**DELEGATED DECISION TO DETERMINE APPLICATIONS FOR
NON-MATERIAL AMENDMENTS**

Reference No: **2026/NM/90249/E**

Site Address: Upper Holme House Farm, Hirst Lane, Cumberworth,
Huddersfield, HD8 8GA

Description: Non material amendment to previous permission
2025/92605 for erection of stables and garage and
formation of riding manege

title General arrangement as proposed
number 21041D-02-P03
scale 1:100, 1:250
size A1

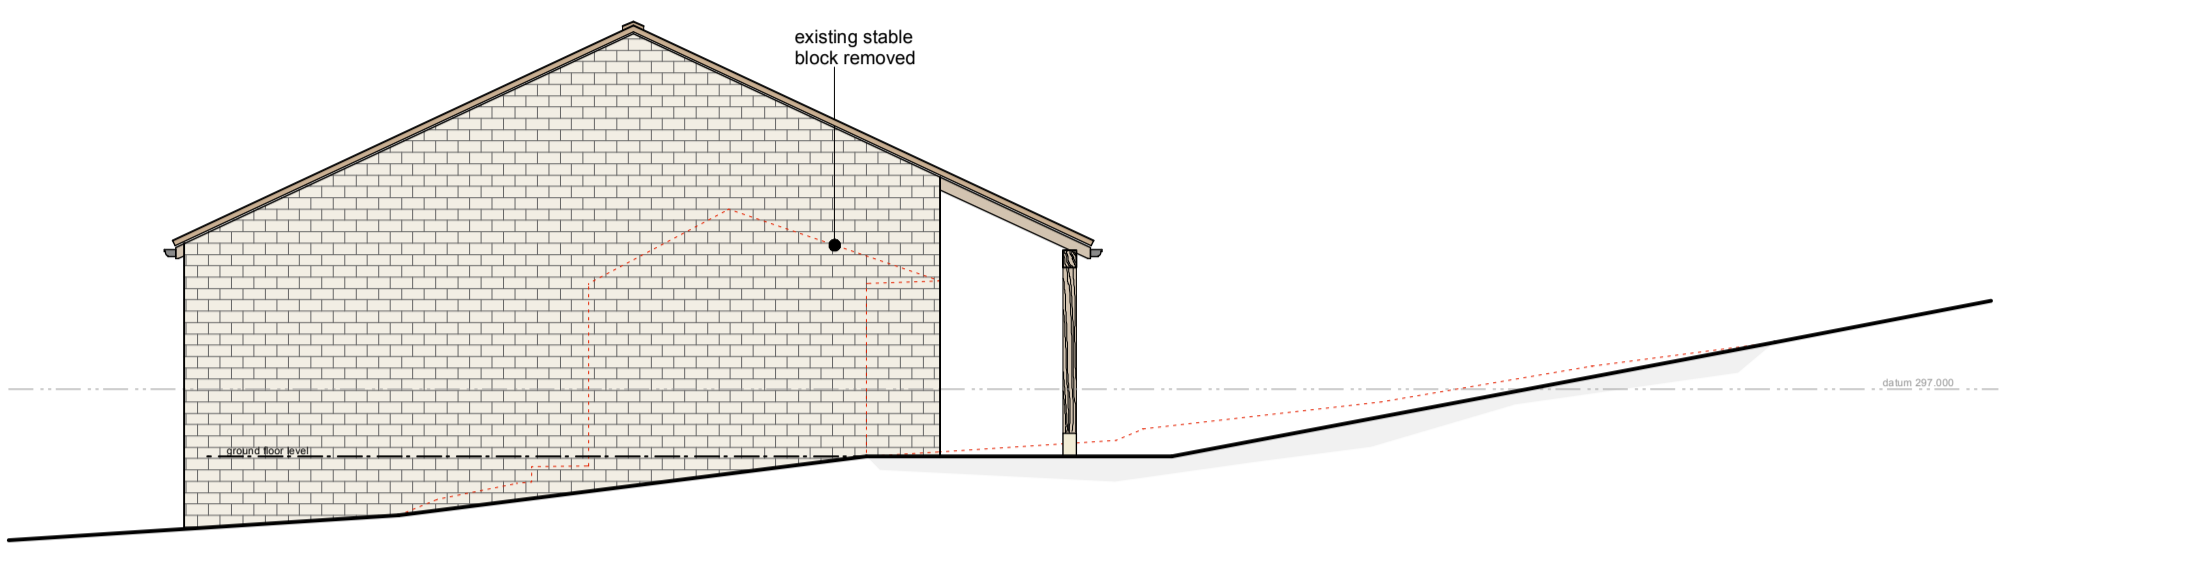
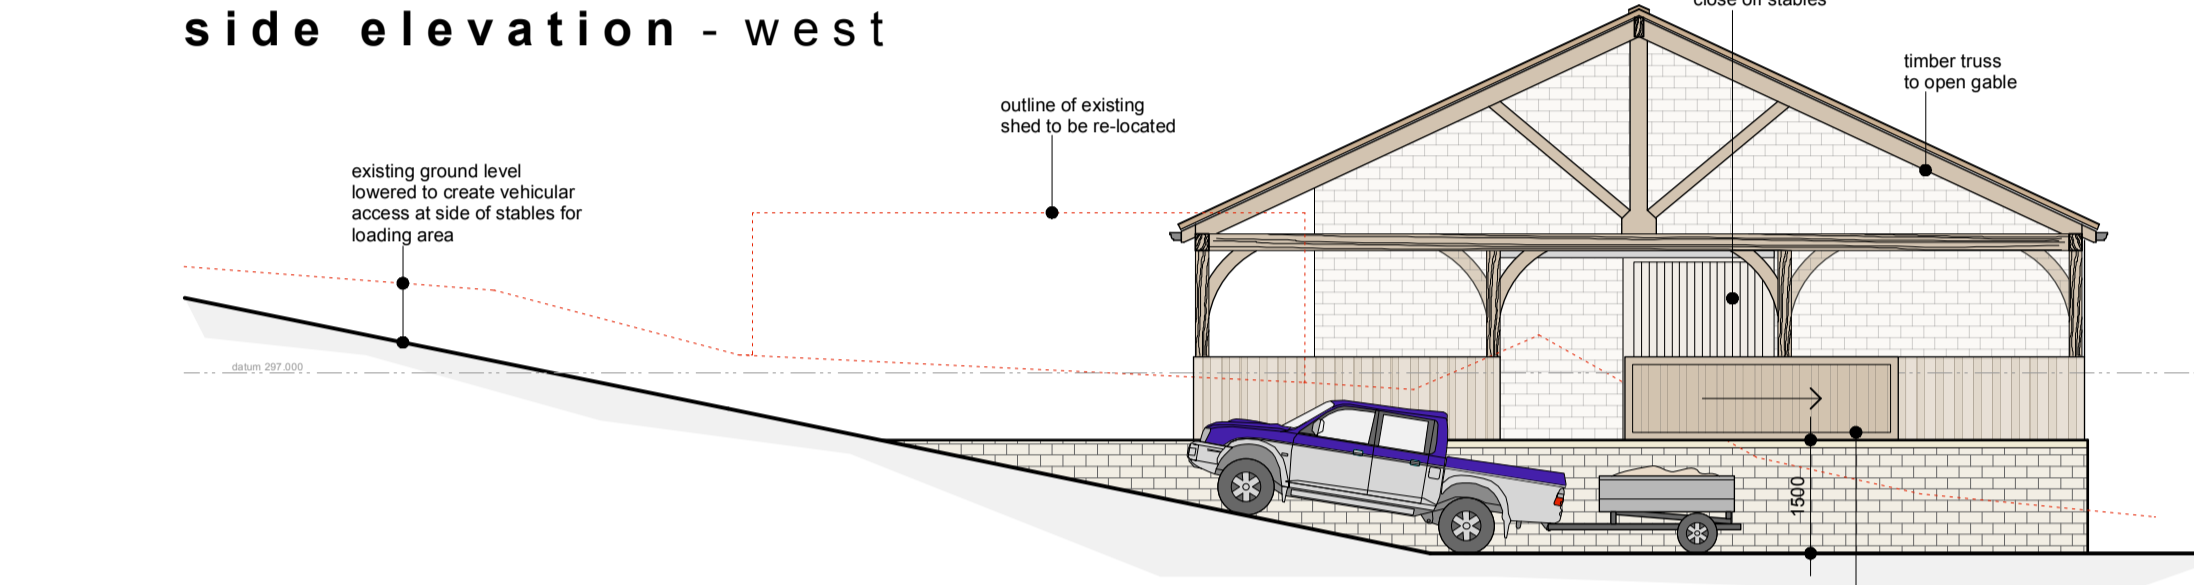
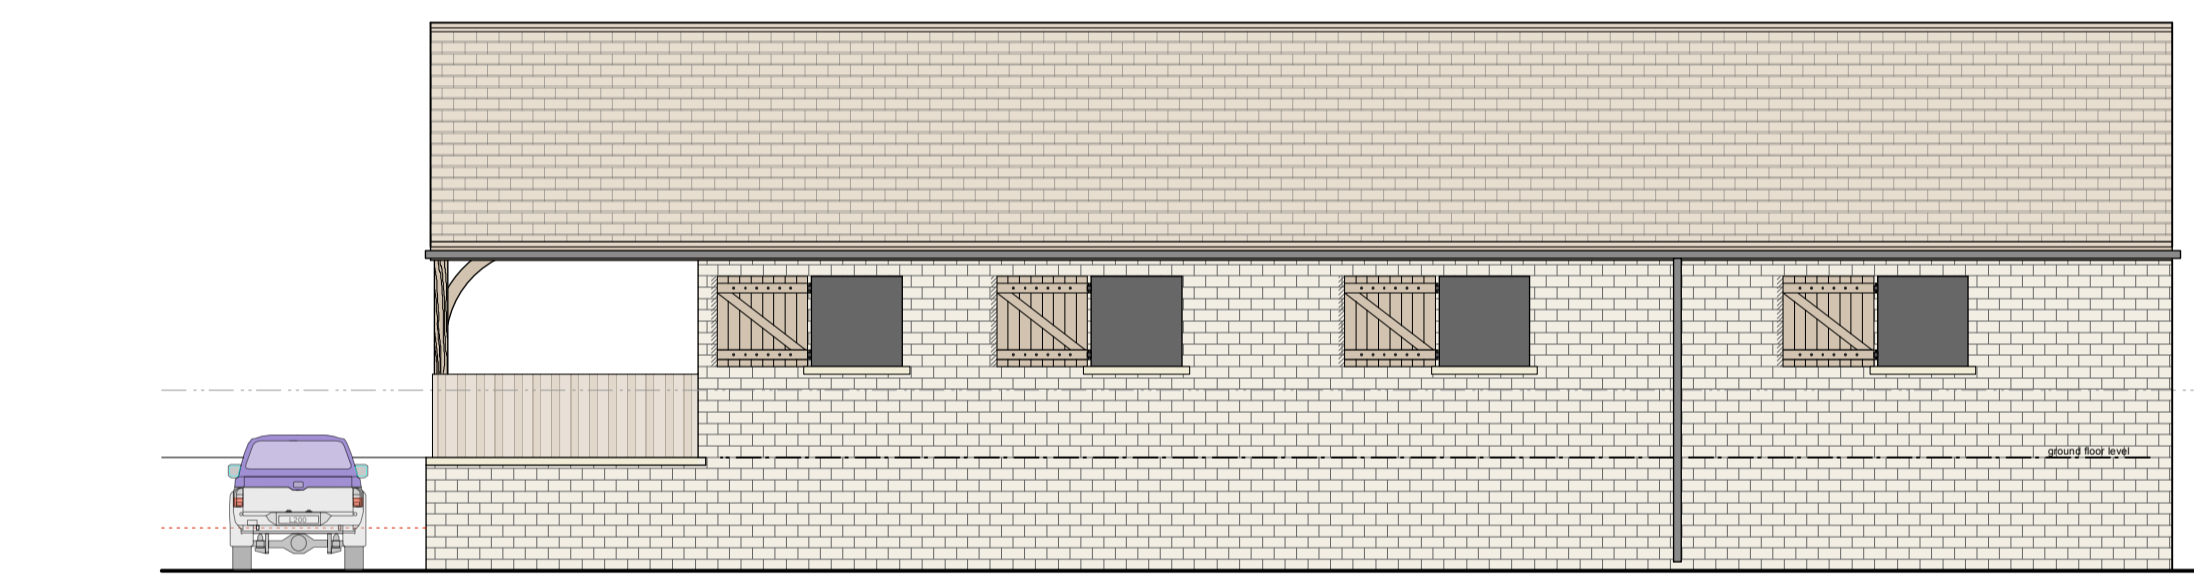
This application seeks a non-material amendment to planning application reference no. 2025/92605, which approved the erection of a stables and garage and the formation of riding manege at Upper Holme House Farm. The amendment seeks to make alterations to the material palette of the approved stables/garage. The external walls would be constructed solely from natural stone. The application form states that the alterations are proposed to provide a more robust construction. This amendment has been outlined within the application form and on plan titled 'General arrangement as proposed' (reference no. 21041D-02-P03, dated 26th January 2026).

1. **Would the change result in a detrimental impact either visually or in terms of living conditions?** It is considered that the proposed changes would not have a detrimental impact upon the living conditions of the occupiers of this property. However, the plans indicate that the proposed amendments would significantly alter the external appearance of the structure. Therefore, given the scale of the changes, there is potential for

harm to the visual amenity of the wider street scene. Furthermore, the proposed amendment would contravene Condition 3 of the original approval which states that the stable/garage building shall be faced in vertical timber boarding for the external walls with a natural stone base and natural stone slate for the roof.
